Application Ref:	2026/0029			 Ribble Valley Borough Council www.ribblevalley.gov.uk
Date Inspected:	N/A	Site Notice:	N/A	
Officer:	AR			
DELEGATED ITEM FILE REPORT:				NMA APPROVAL

Development Description:	Non-material amendment to application 3/2022/1158 involving replacing plots 5 and 67 from Bowell to Wasdale house type and changes to the building façade and garage alignment of plots 3, 4, 73 and 74.
Site Address/Location:	Land South of Accrington Road Whalley BB7 9TD

DRAWING TITLE
Kirkstone V2 Attached Garage House Type
Floor Plans & Elevations
DRAWING NUMBER
015KIRK-V2-AG-P03

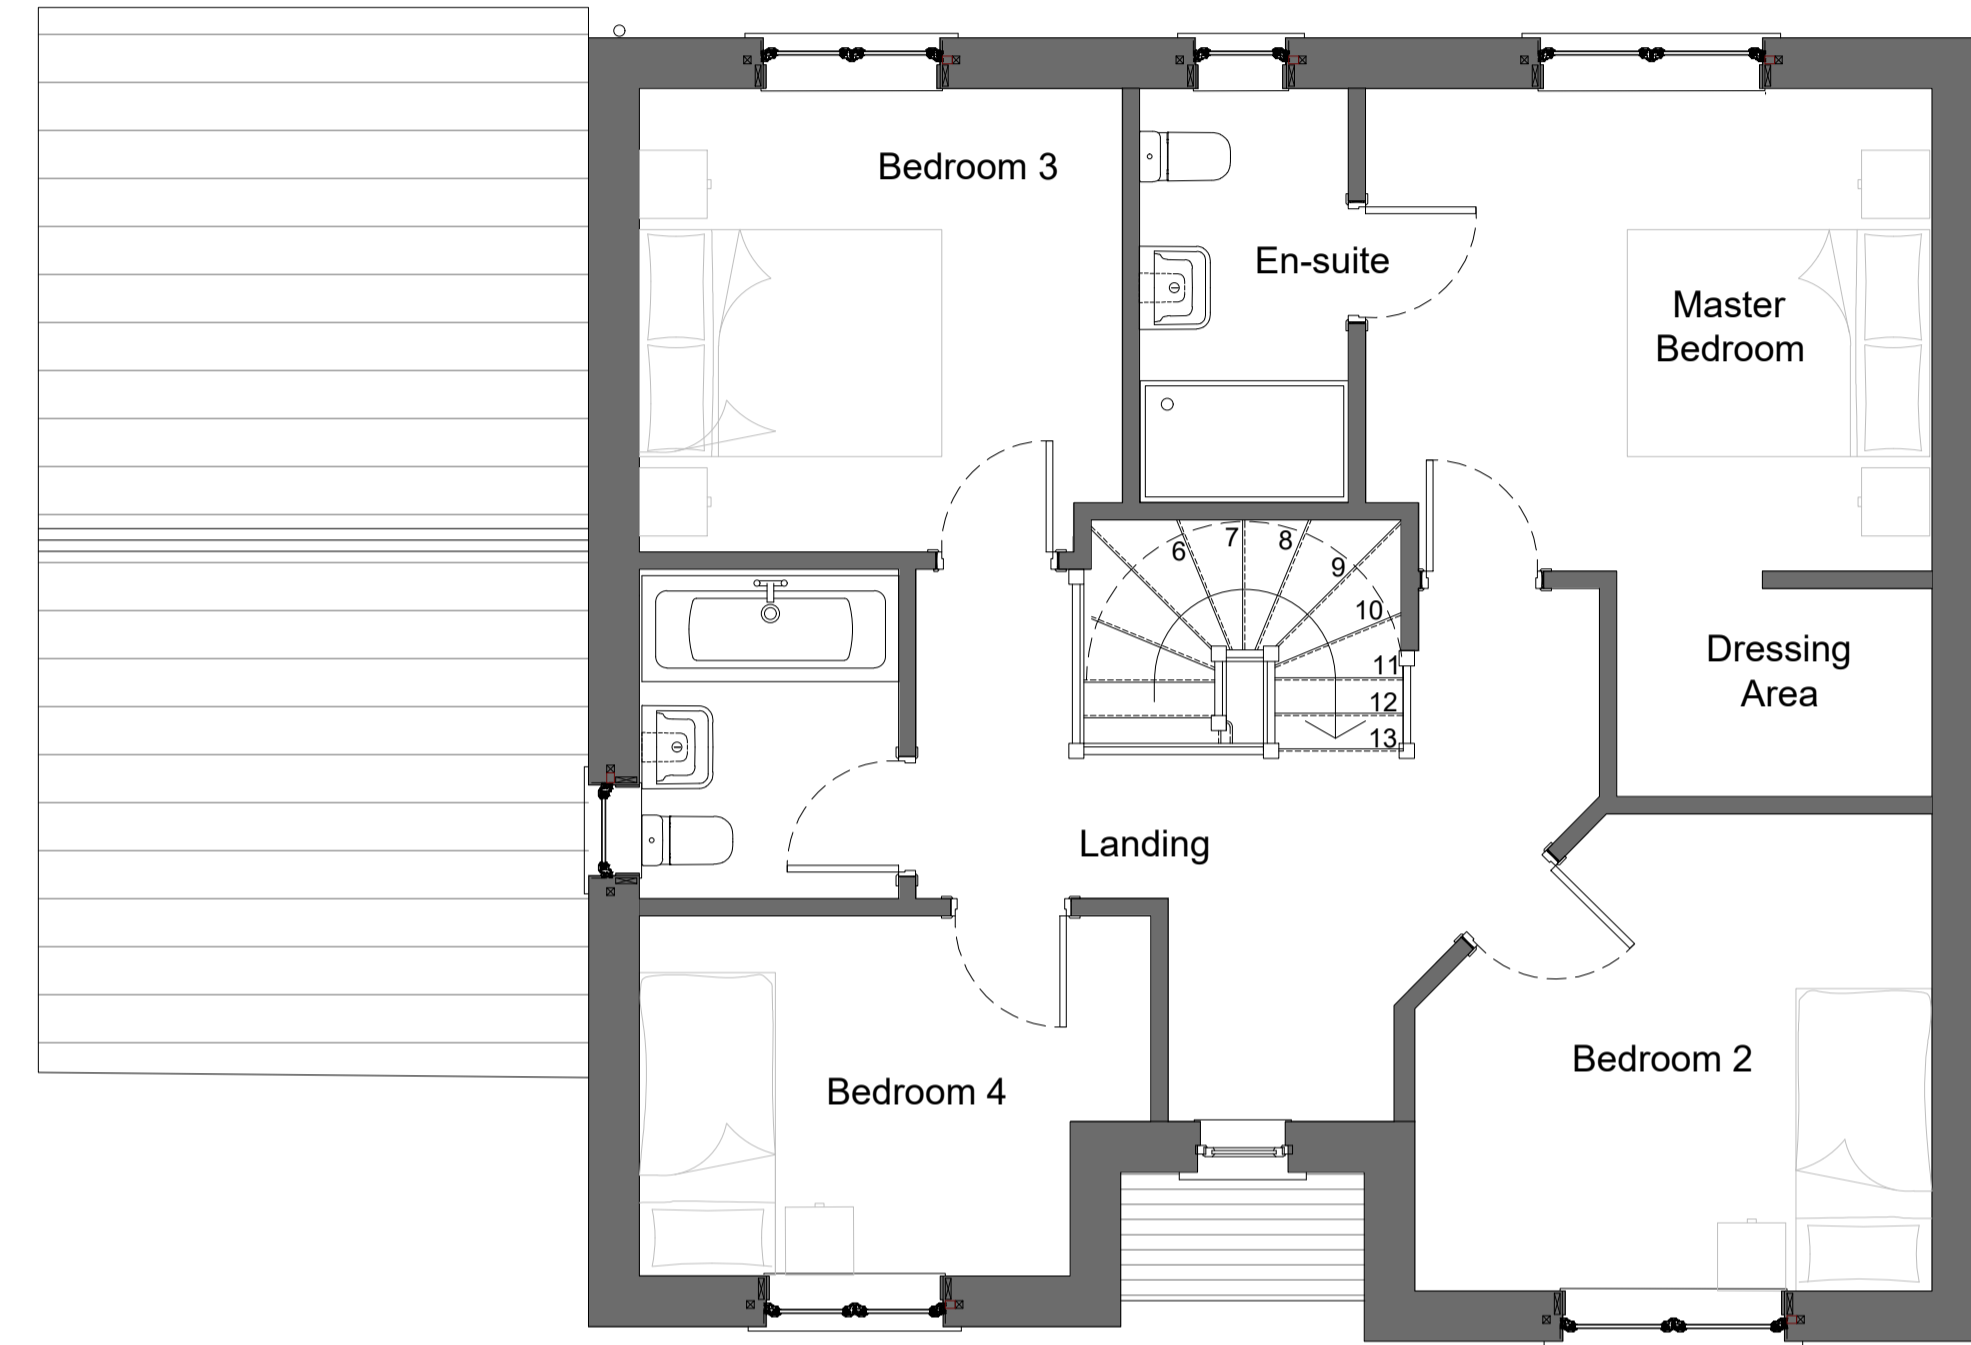
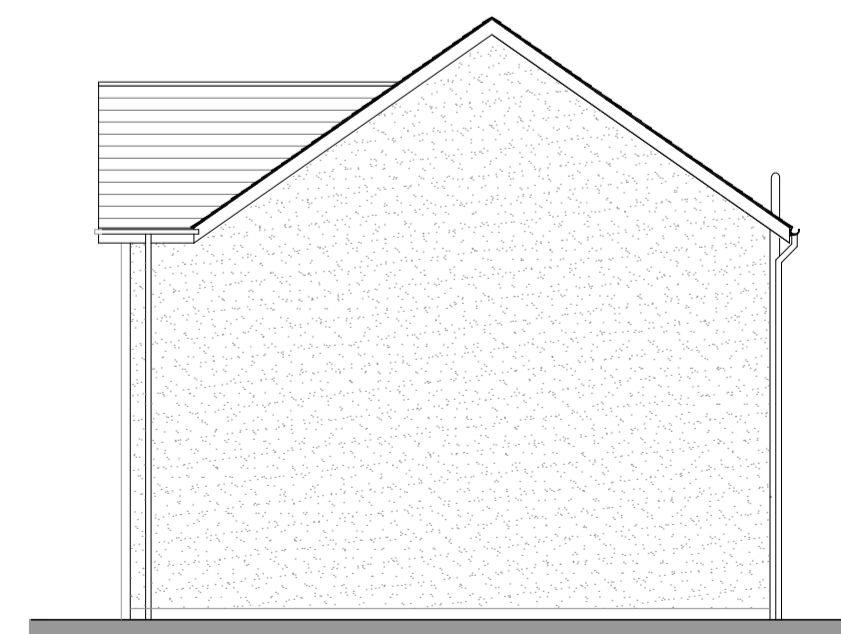
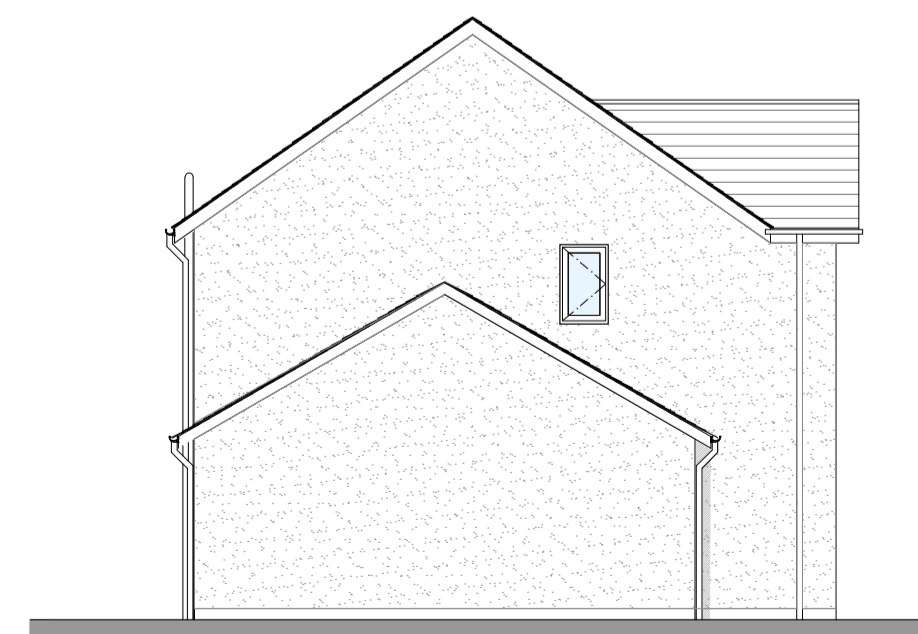
The amendment of Plot 73's house type to Kirkstone would see the introduction of a first floor window on the south-west elevation serving a bathroom, but this would be at an oblique angle to the western boundary, and with the interface distance involved would not result in any overlooking issues, furthermore the impact is not materially different that the previously approved first floor window in the south-west elevation of plot 74.

The submitted details further seek consent for a non-material amendment to the Kirkstone house type, whereby the two pediments to the buildings faced are slightly increased in width, the garage is realigned to run flush with the rear elevation and the approved window and door layout on the side elevations is replaced with a singular upper-storey window on the opposite side elevation. The new external footprint as well as the external appearance would be a nominal deviation from the house type previously approved.
